memorandum

date December 17, 2019

subject Review of 5637 East Mercer Way – Reasonable Use Exception Application (CAO 15-001 and SEPA15-001)

Drawing file: SEPA MDNS reference materials / healey alliance site plan received 11-13-2019.pdf

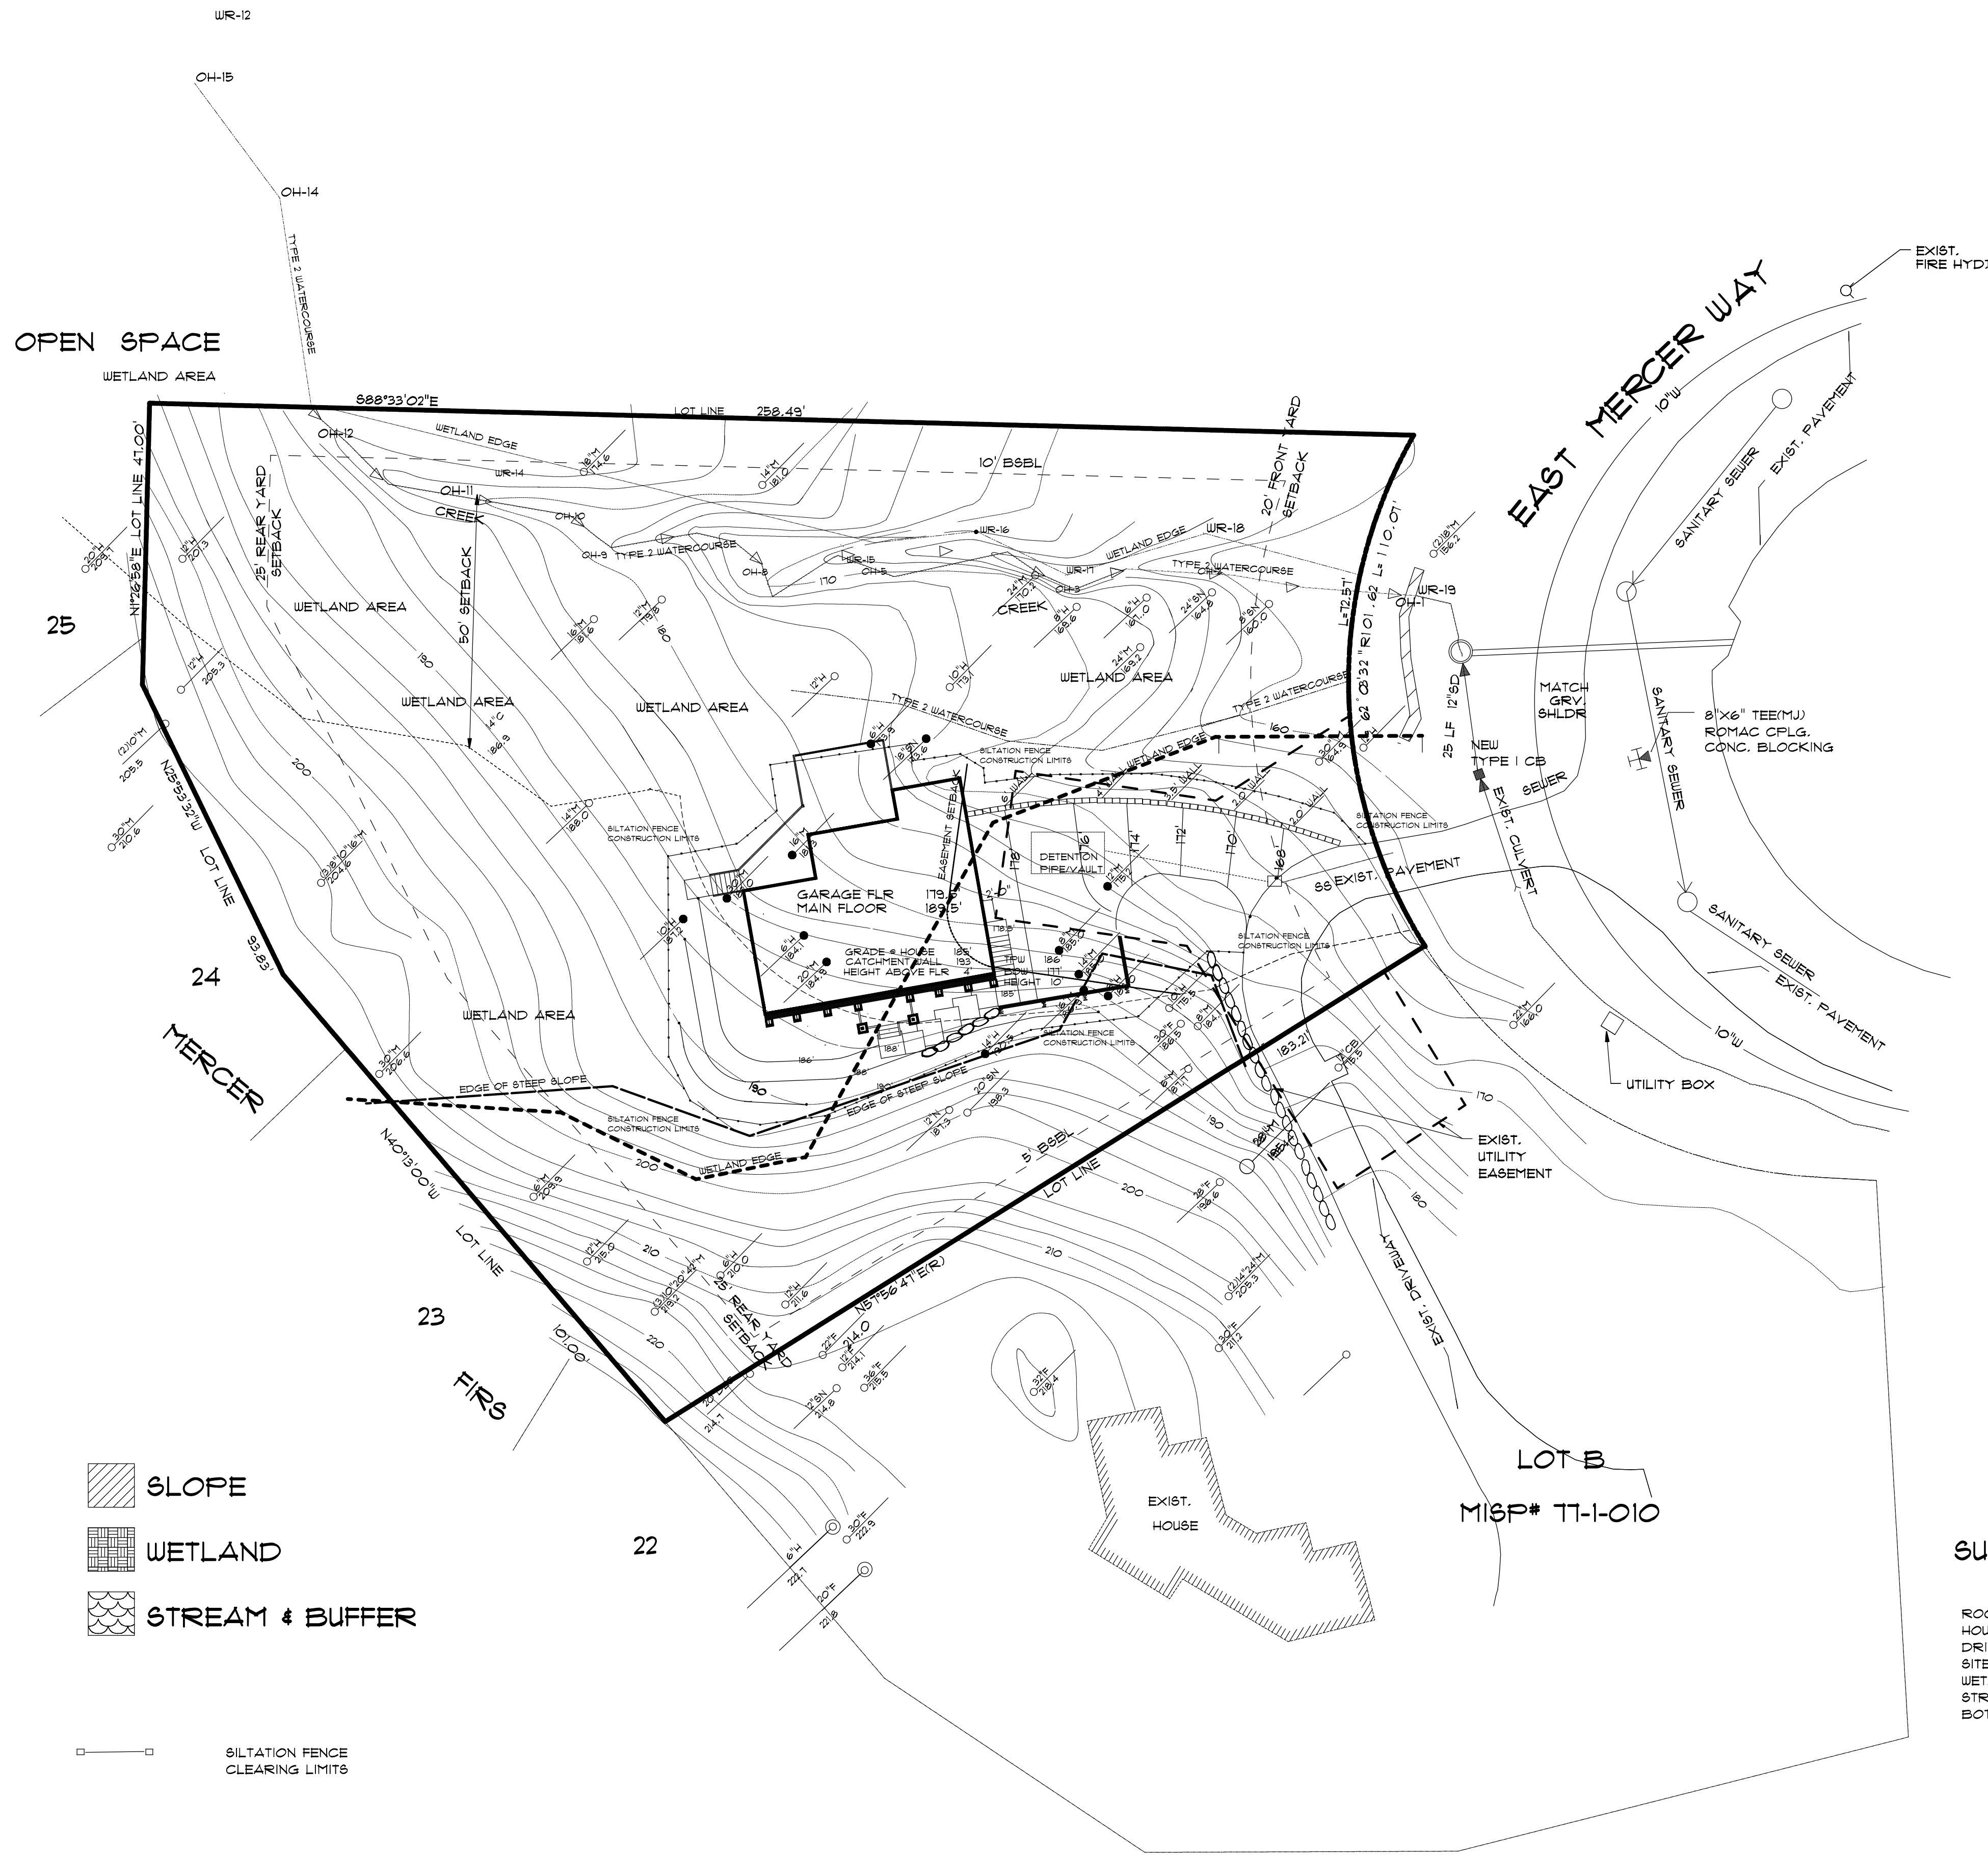
The June 2019 ESA letter asked the applicant to confirm that buffer mitigation will be carried out at a 1:1 mitigation ratio. Sewall responded that the October 30, 2019 revised mitigation plan provides for 1:1 enhancement; however, impact numbers are not consistent between Sewall's October 2019 figures and those provided by The Healey Alliance AZ, dated October 23, 2019. Impact areas for both design sheets should be validated and be consistent.
